**MODIFICATION REQUEST:
61 Mobbs Lane, Epping (Former Channel 7
Site)
(MP 10_0107 MOD 3)
Minor Design Changes to Building 2**

Director-General's
Environmental Assessment Report
Section 75W of the
Environmental Planning and Assessment Act 1979

February 2012

B2 Elevations (A1005-B) Rev A - South Elevation

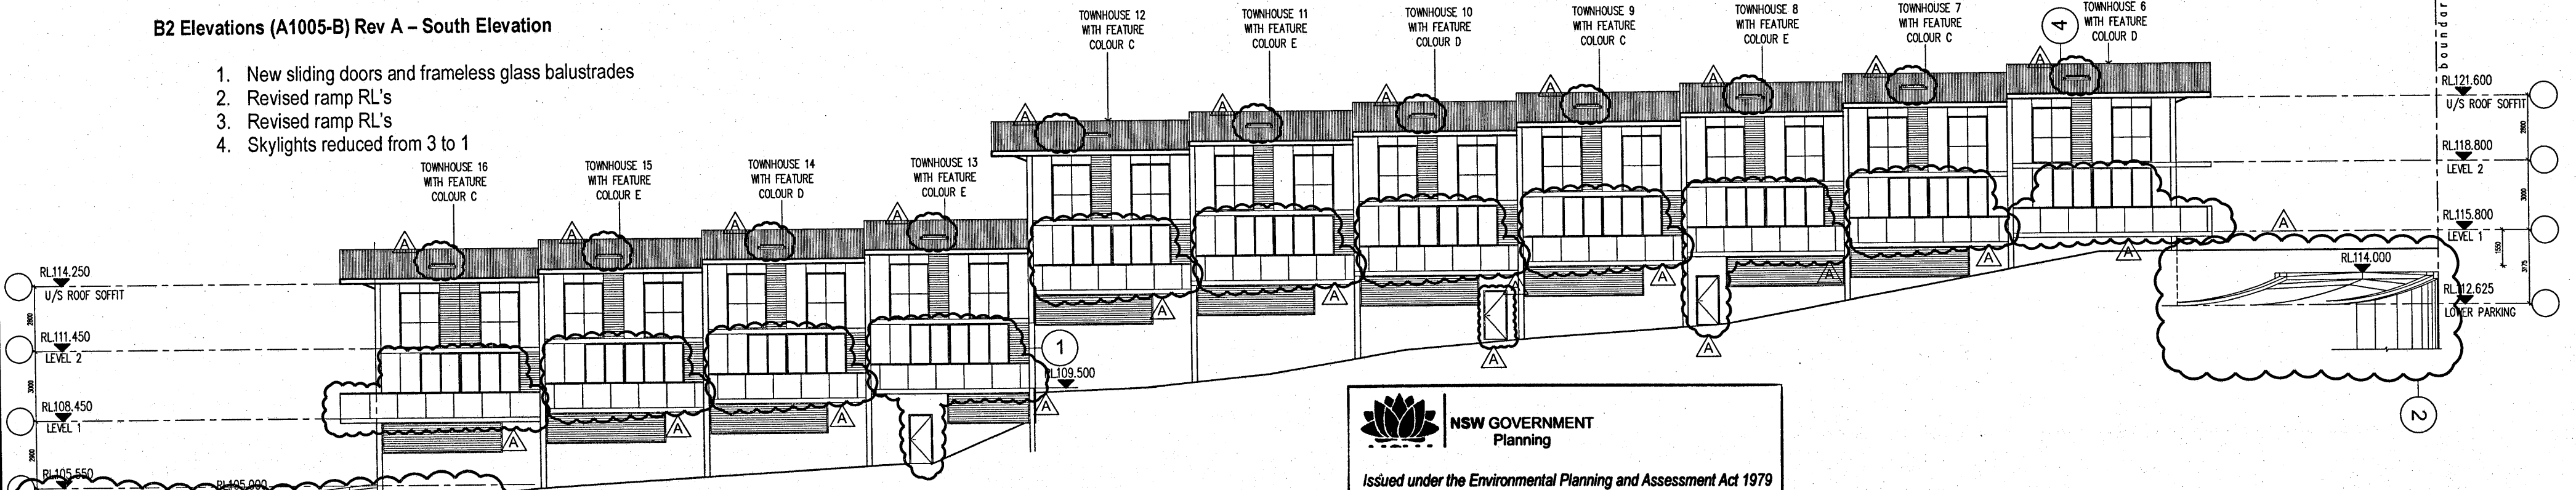
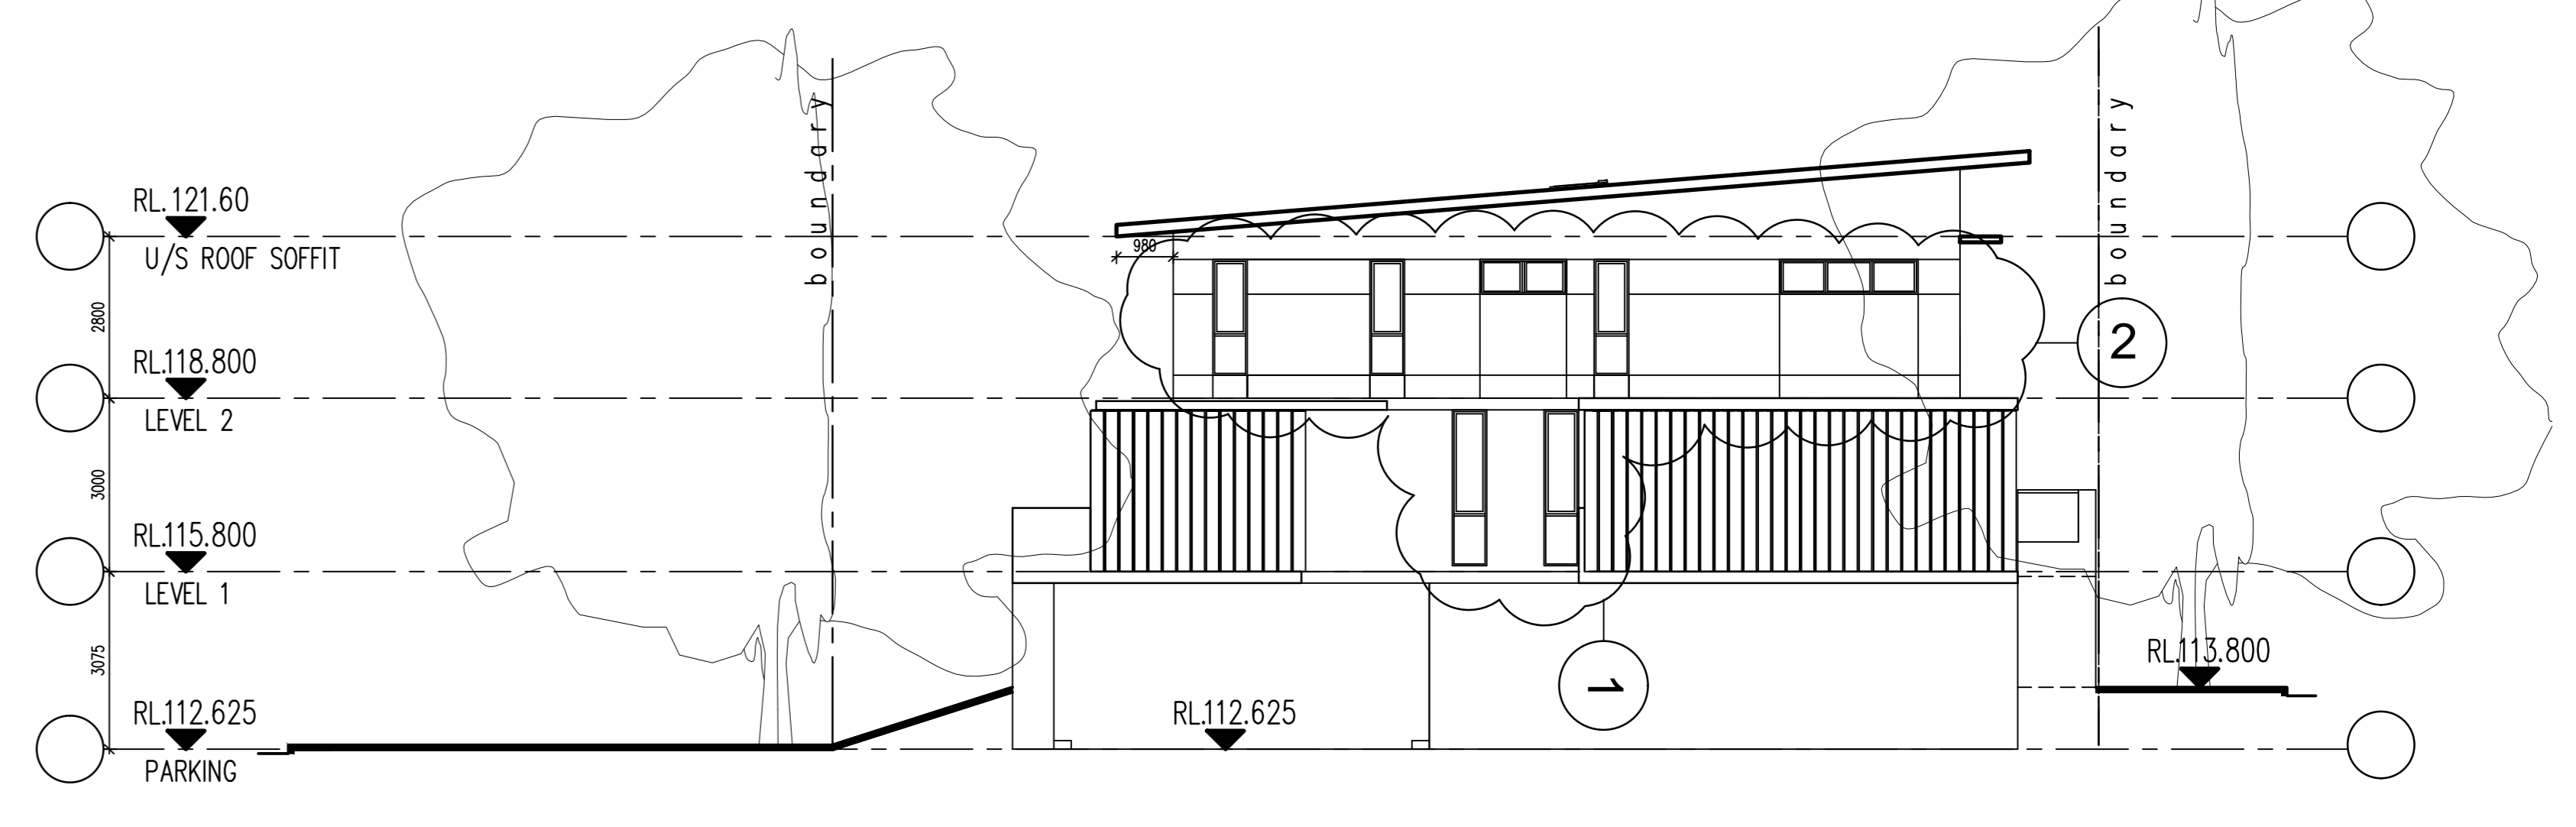
The proponent has identified inconsistencies between the approved floor plans and the elevations for building 2 (drawing numbers A1005-B and A1003-D). As previously stated, these inconsistencies relate to the exclusion of an upper level balcony on the southern elevation of townhouse 16, and the incorrect positioning of windows on the eastern elevation of townhouse 6. Diagrams identifying the inconsistencies between the approved floor plans and elevations, and how these will be rectified via the submission of revised plans are provided at **Figures 6** and **7** overleaf.

Figure 6: Proposed Revisions to the Southern Elevation to Correct Drawing Errors

Comment: The department is satisfied that there are no inconsistencies between the approved floor plans and the revised elevations. In addition, the department considers that

Given the above, the department considers that the modifications proposed to rectify the inconsistencies between the approved floor plans and elevations are acceptable.

B2 Elevations (A1005-B) Rev A - East Elevation

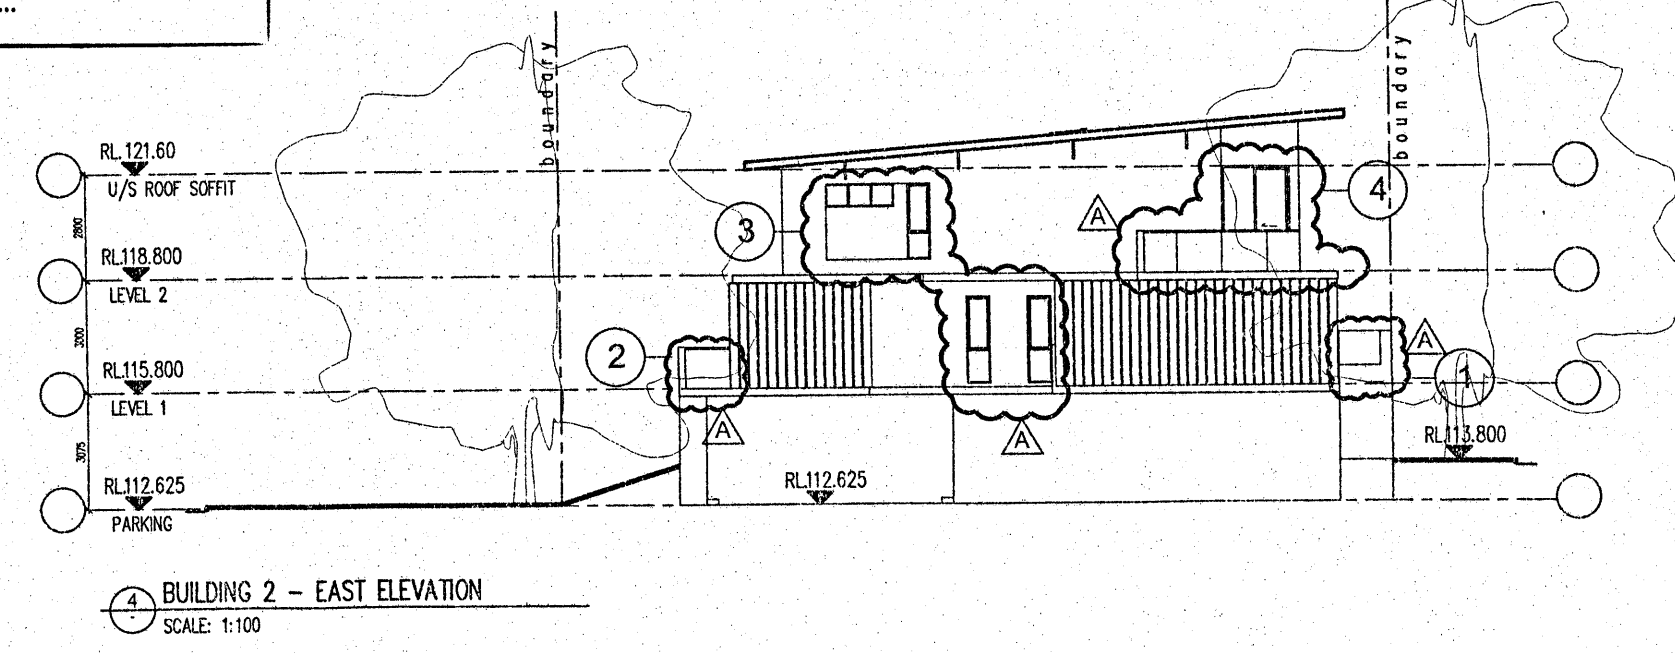
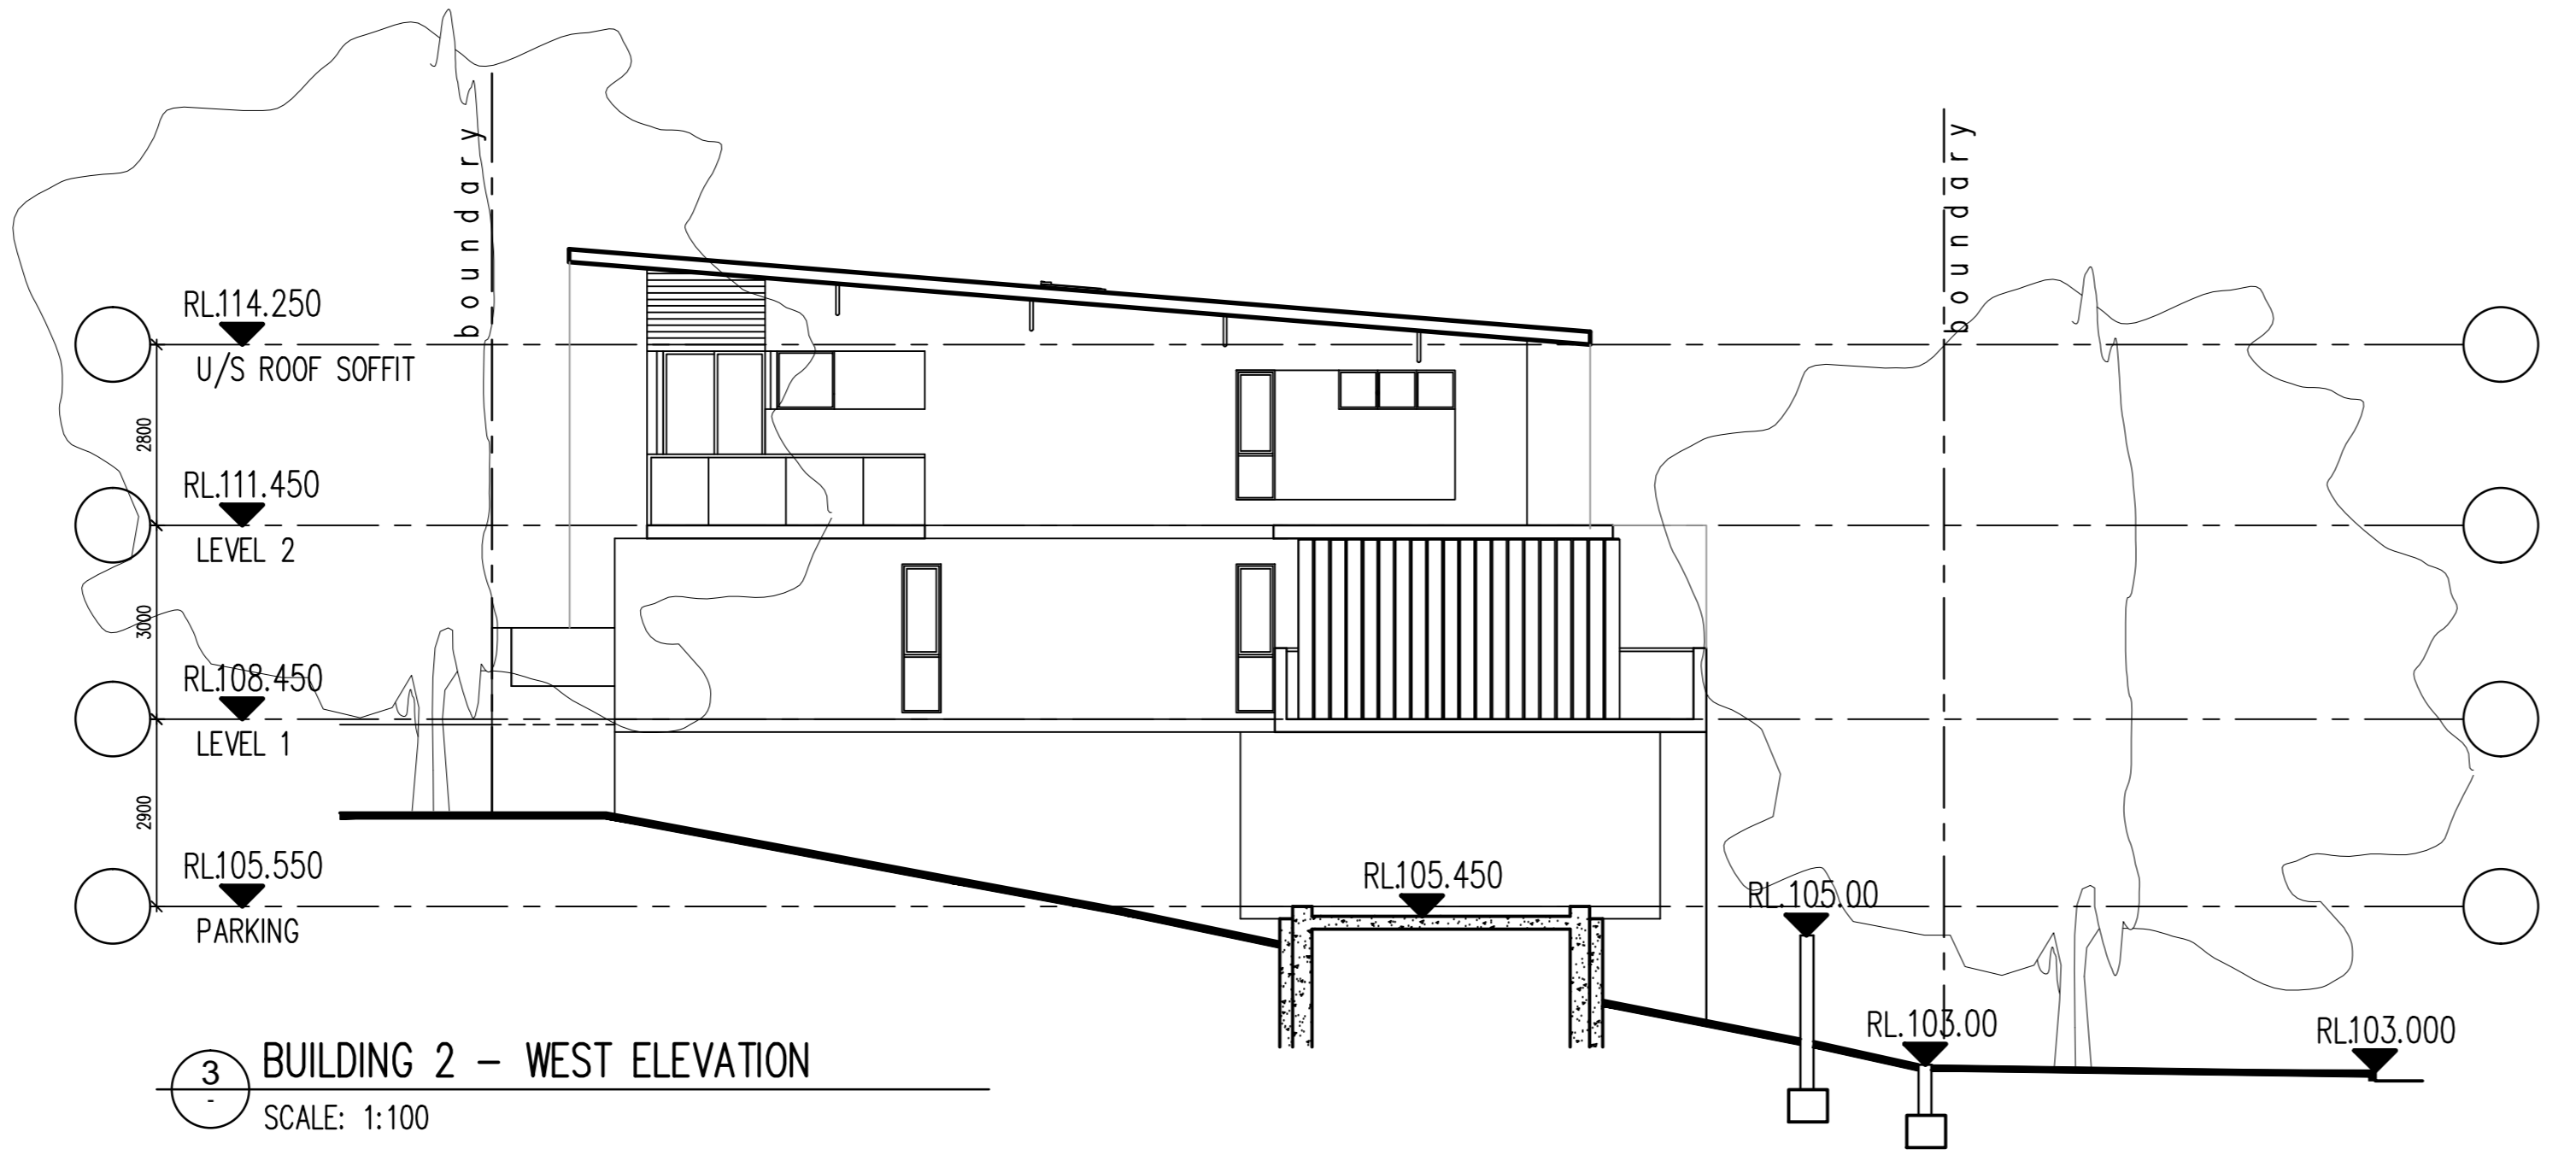
Figure 7: Proposed Revisions to the Eastern Elevation to Correct Drawing Errors

the revisions proposed to the eastern elevation of townhouse 6 would not result in any unacceptable privacy impacts at townhouses 5 or 6 given that:

- the extent of glazing is generally consistent with the original project approval, and the use of the rooms along the eastern elevation of building 2, and the western elevation of building 1 remain unchanged
- there is a 33 m setback between townhouses 5 and 6. This exceeds the minimum 12 m setback recommended to maintain privacy between two habitable rooms in the Parramatta Development Control Plan 2011, and the Residential Flat Design Code.
